The Sizewell C Project

**Natural England's Written Summary of Oral Representations made at Issue
Specific Hearing 7: Biodiversity and Ecology on 15th and 16th July 2021**

Planning Inspectorate Reference: EN010012

23rd July 2021

DRAWING NO:
SZC-SZ0100-XX-000-DRW-100205

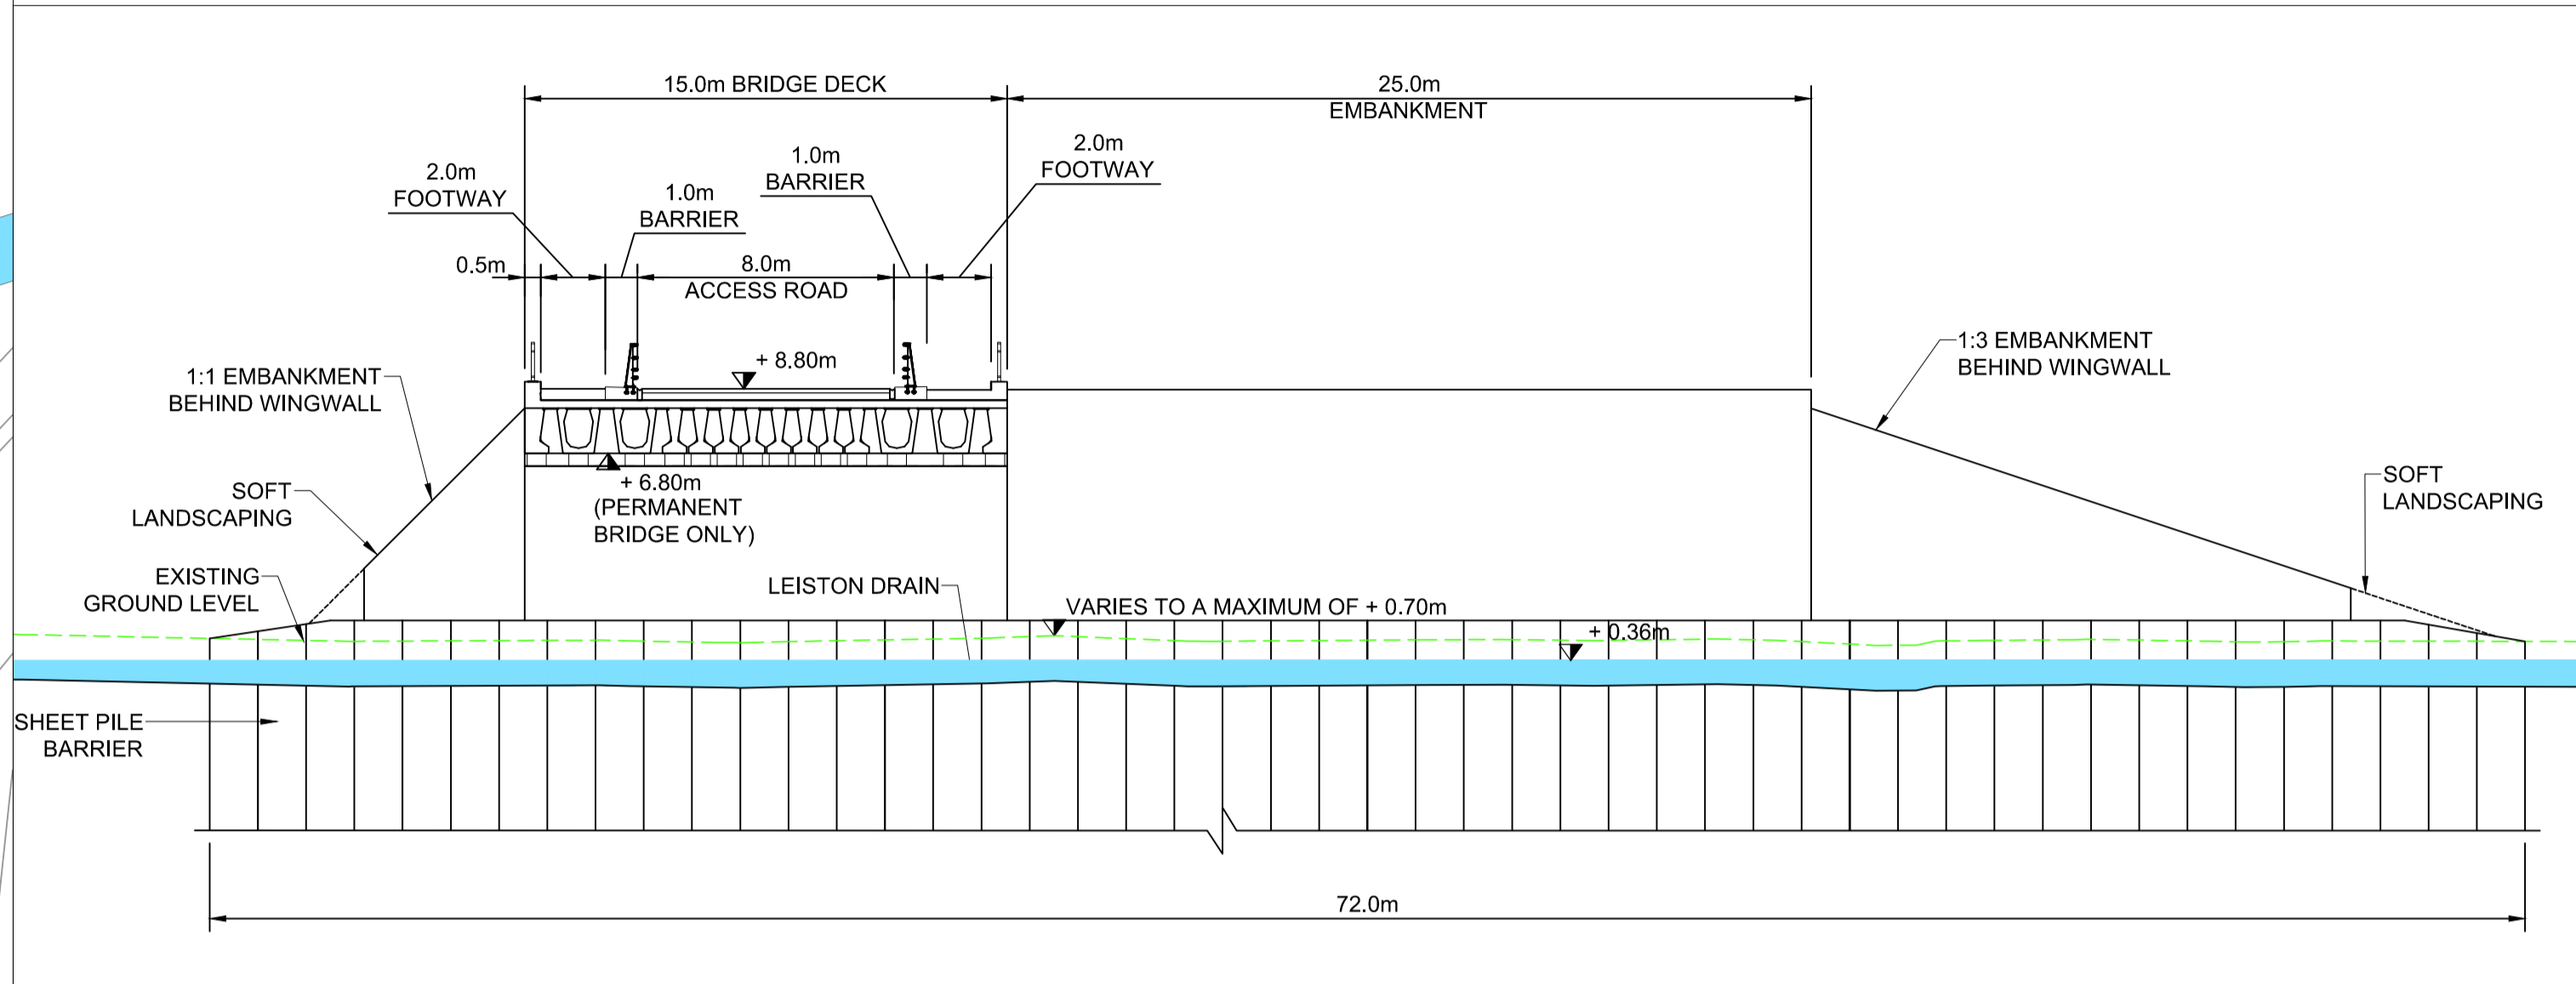
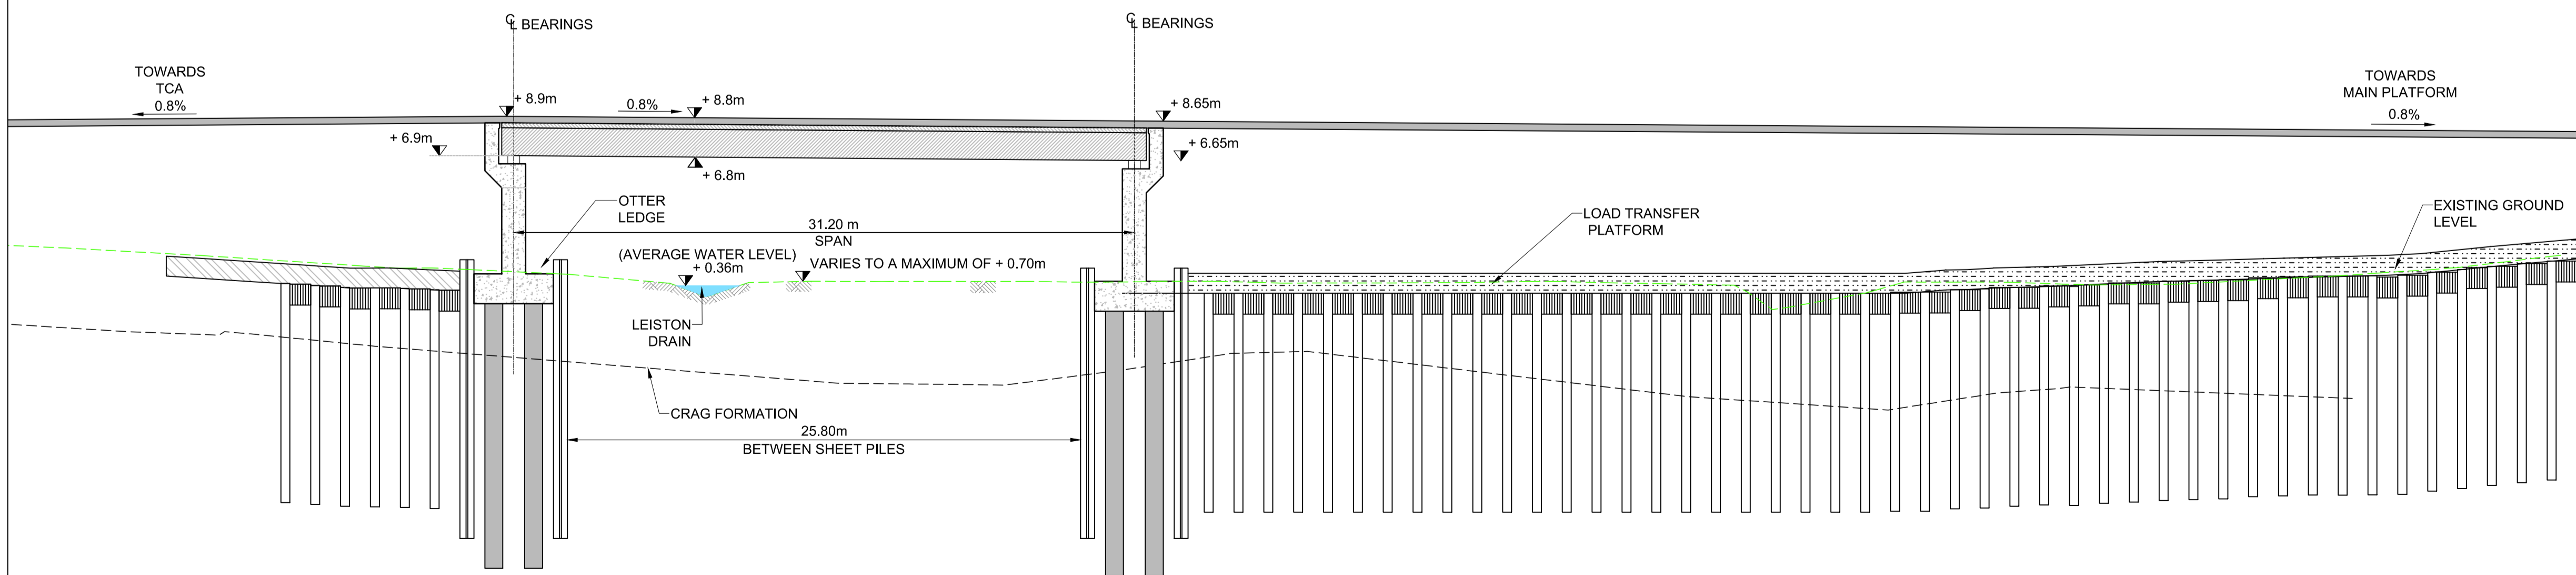
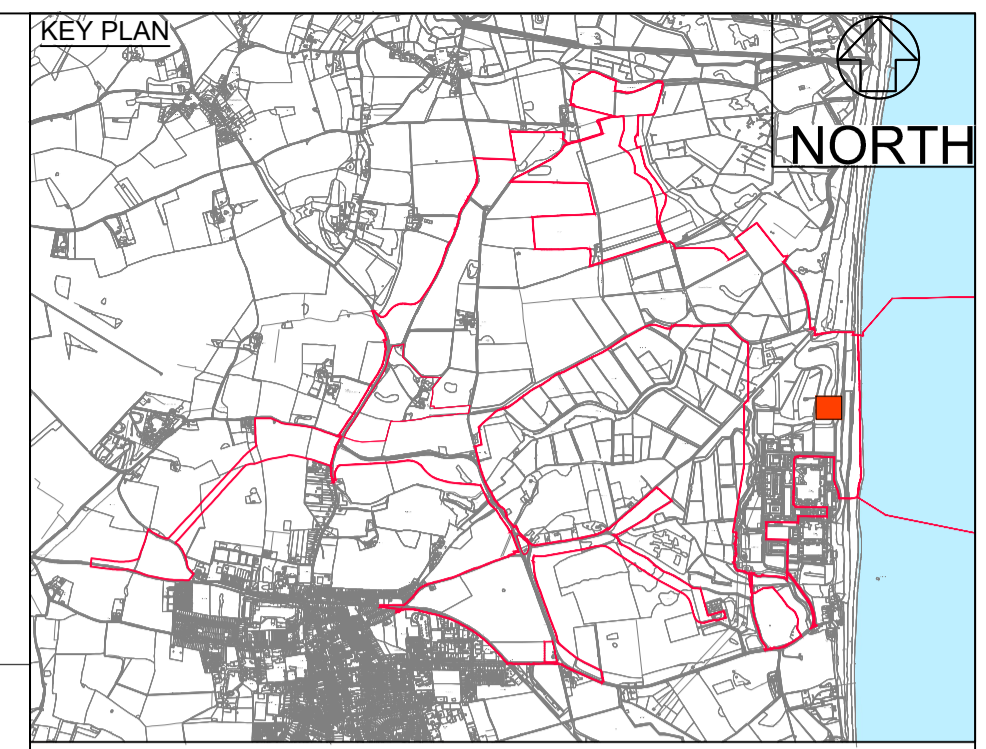
To summarise, our advice remains that the crossing design should be that which minimises land take from the SSSI. The project should clearly follow the avoidance-mitigation-compensation hierarchy in terms of impacts to high value ecological receptors of national importance such as the SSSI and include consideration of less damaging alternatives where available, as per section 4.4. and paragraph 5.3.7 of NPS EN-1. The three-span bridge which was presented as a viable design option at pre-application would appear to be a preferable alternative in this regard.

The judgement of reasonable alternatives is one for the decision maker to consider. Should the current hybrid bridge-embankment design be considered justified, then ecological improvements can be made in our opinion (soffit height of at least 6m), especially for the benefit of invertebrates to allow sufficient light penetration for their dispersal while retaining the positive aspects of the design in terms of hydrology and reduced land take.
